SOUTH HOLLAND DISTRICT COUNCIL

To: Planning Committee - 05 October 2022

Purpose: To consider Planning Application H16-0704-22

Description: Installation of historic stone drinking fountain together with protective railings and surround base etc within Ayscoughfee Hall Gardens - re-submission of H16-0387-22

Drawing Number:	Rev:
A1572-02	P5

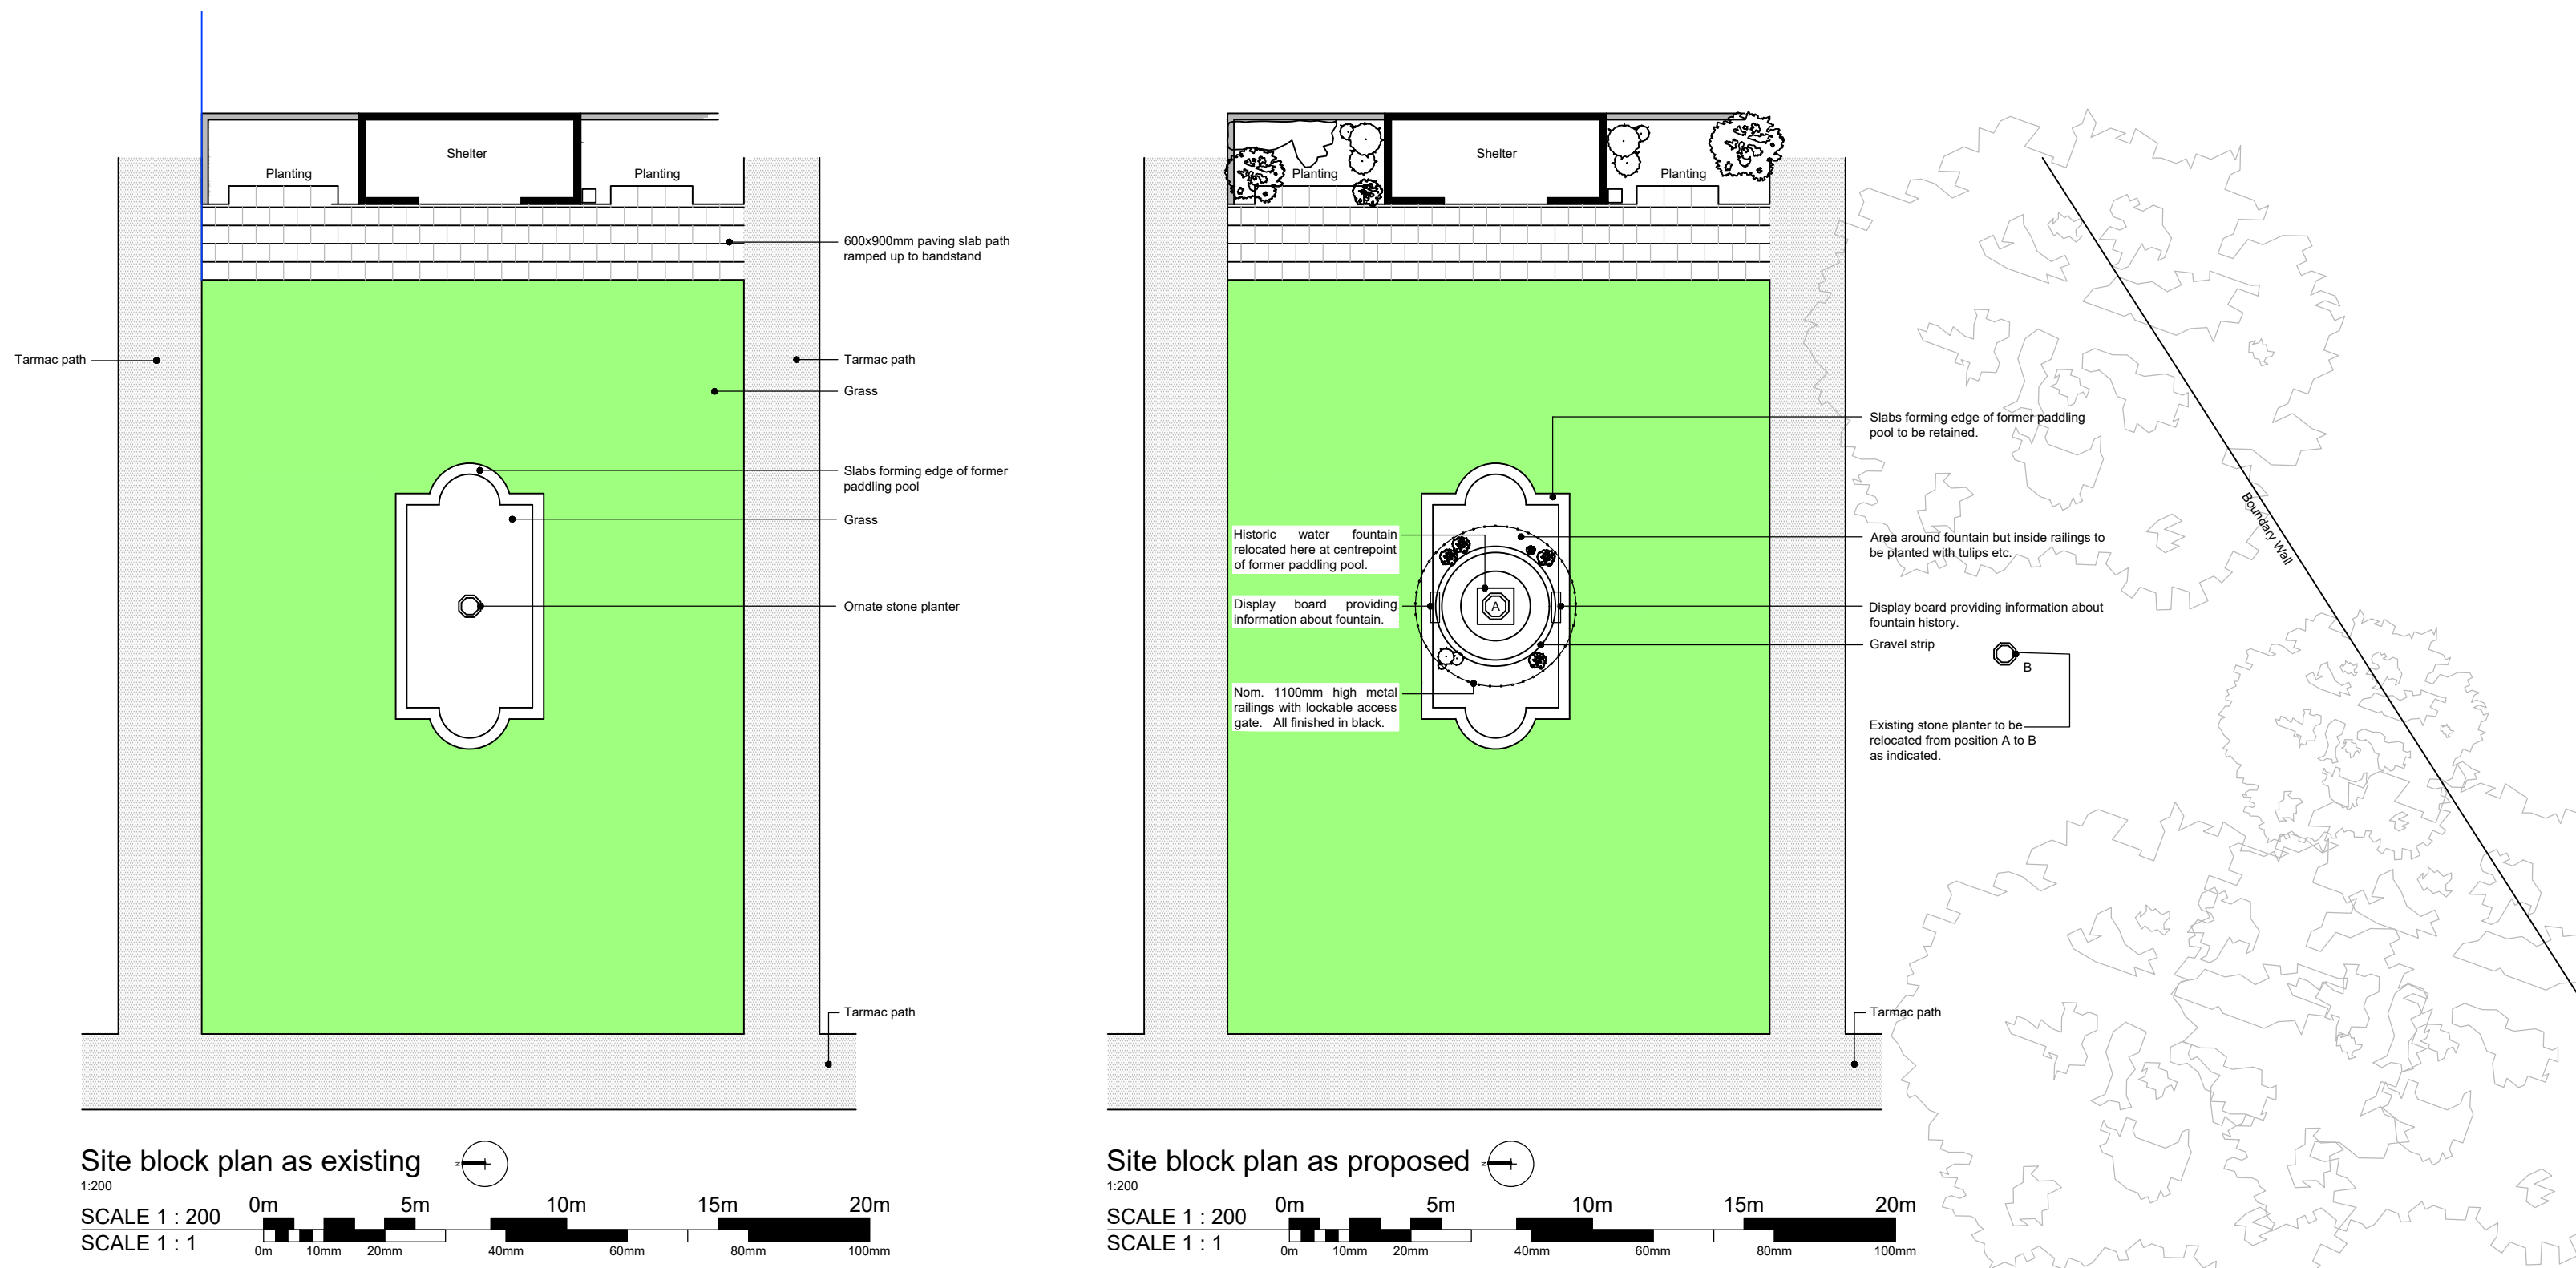
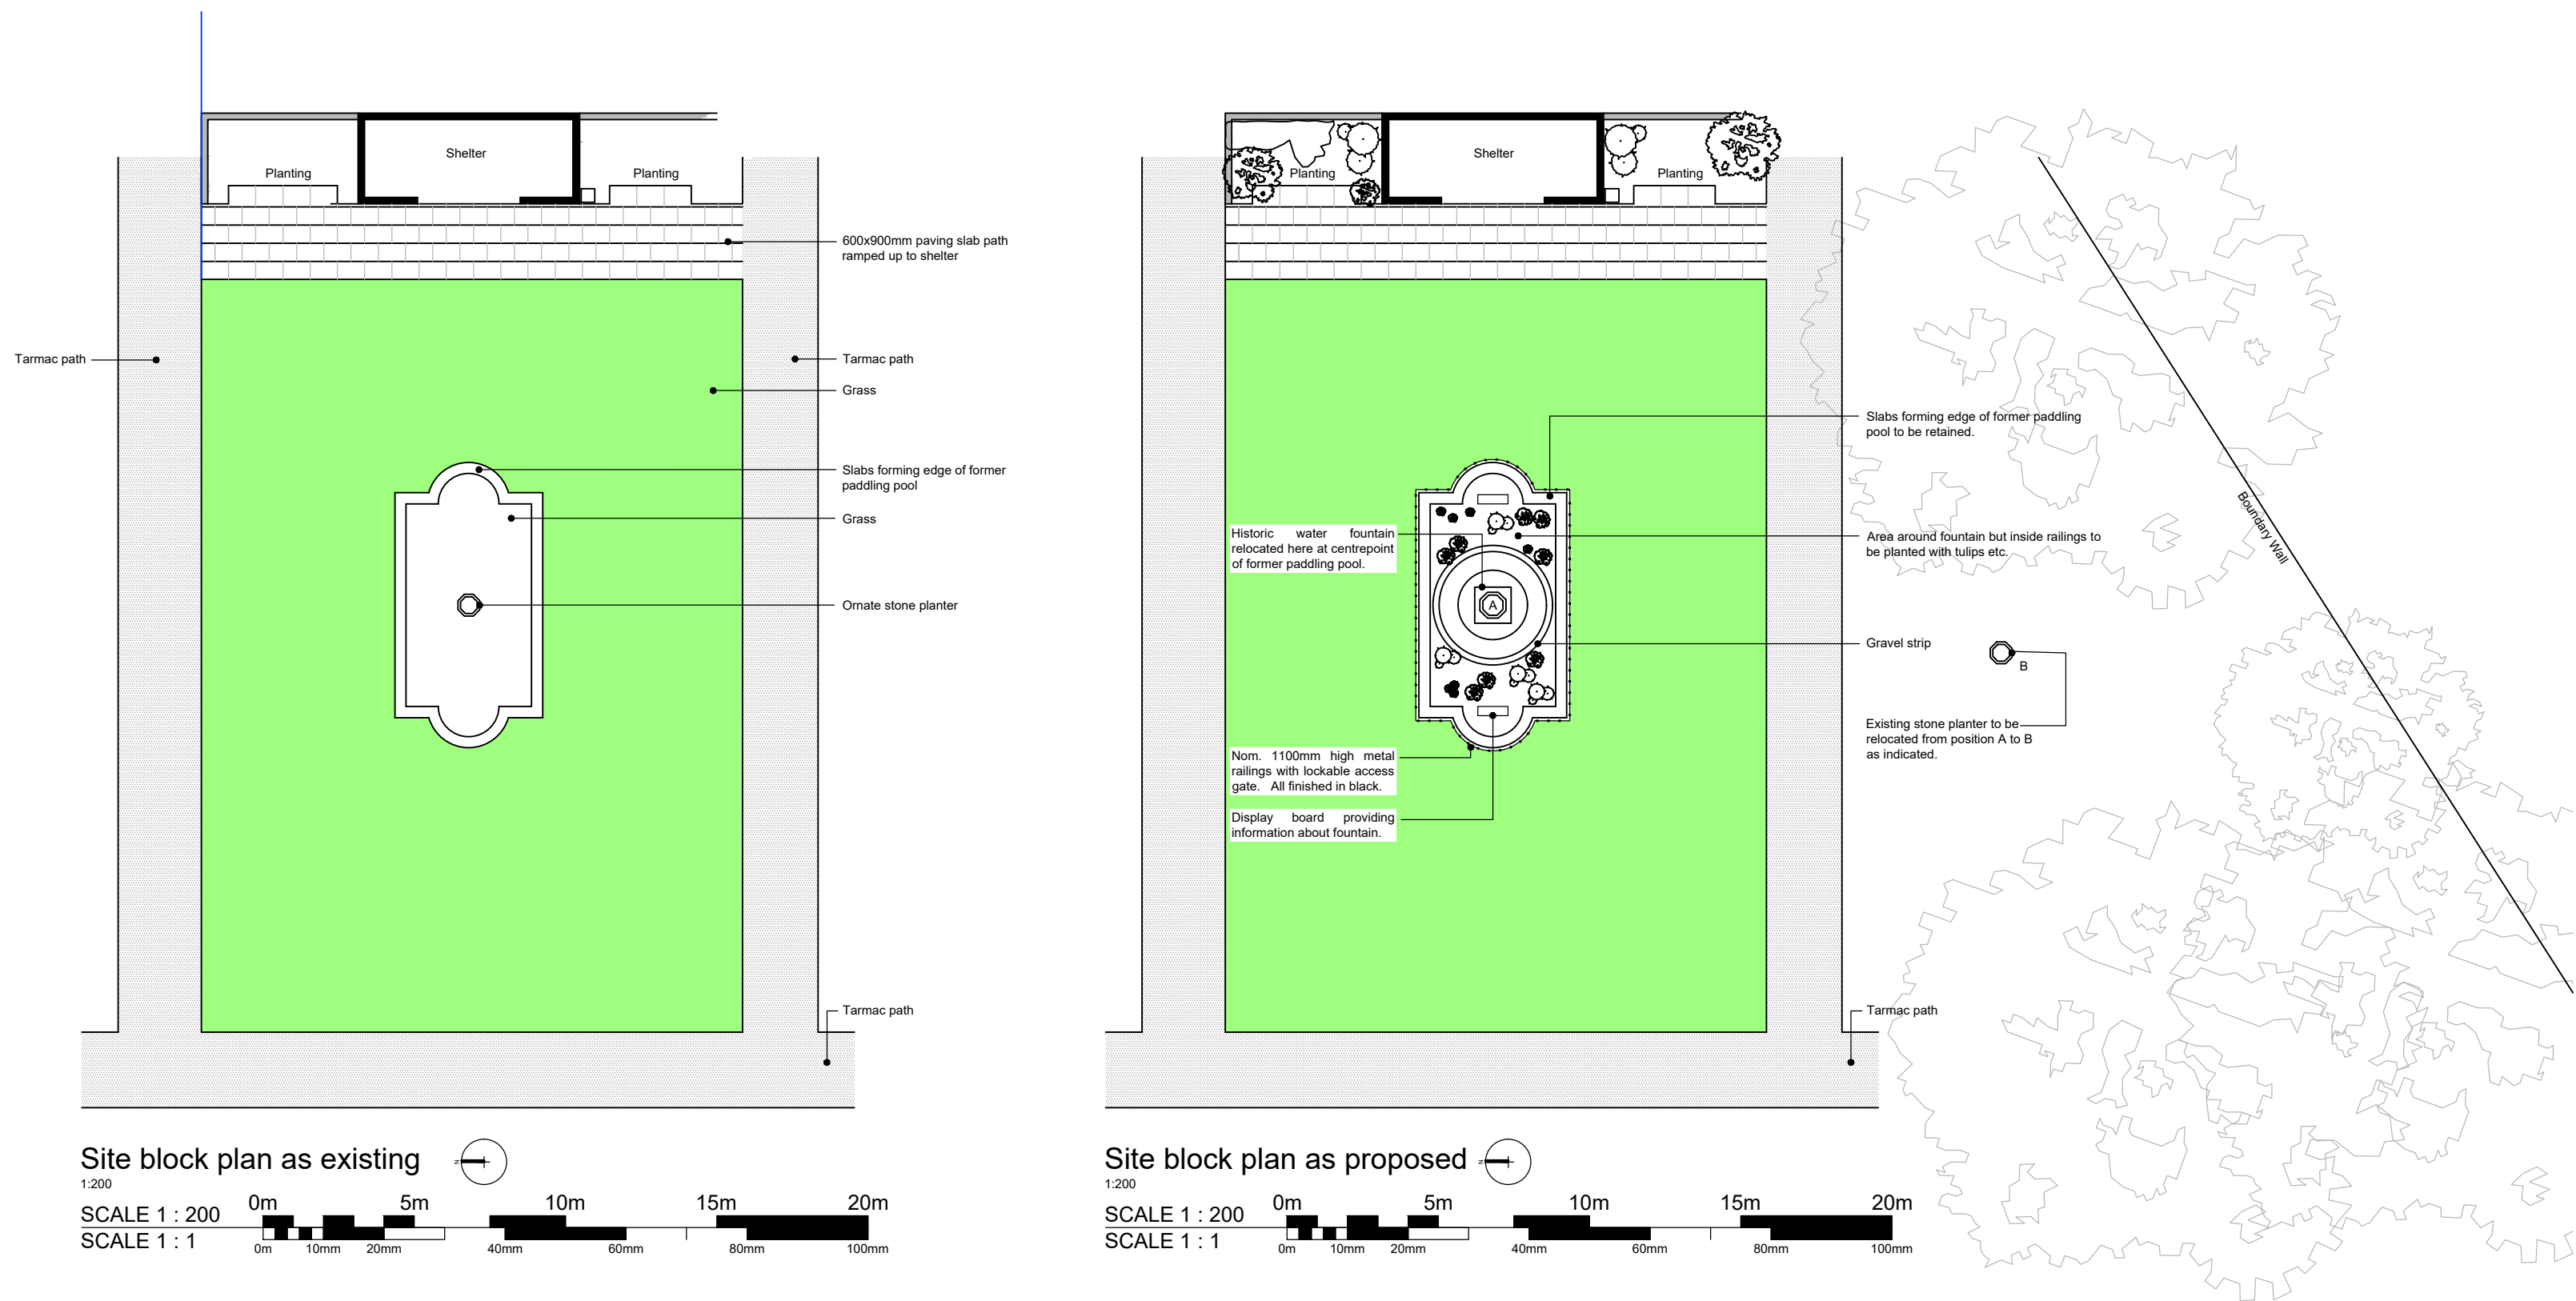
Historic England did object to the originally proposed railing layout, which was to be a circle surrounding the fountain which overlapped the stone pool outline. The application has since been amended to their exact recommendation for an acceptable alternative.

- 7.6 For the above reasons, it is considered that this location is an acceptable and viable choice for locating the Mary Ann Johnson fountain.
- 7.7 The proposed railings would be oriented in a way which does not harm the visual remains of the paddling pool or the fountain. The railings would be constructed of black metal and would be minimal in scale such that they should not harm the appreciation of the fountain or the wider historic setting and context at large.
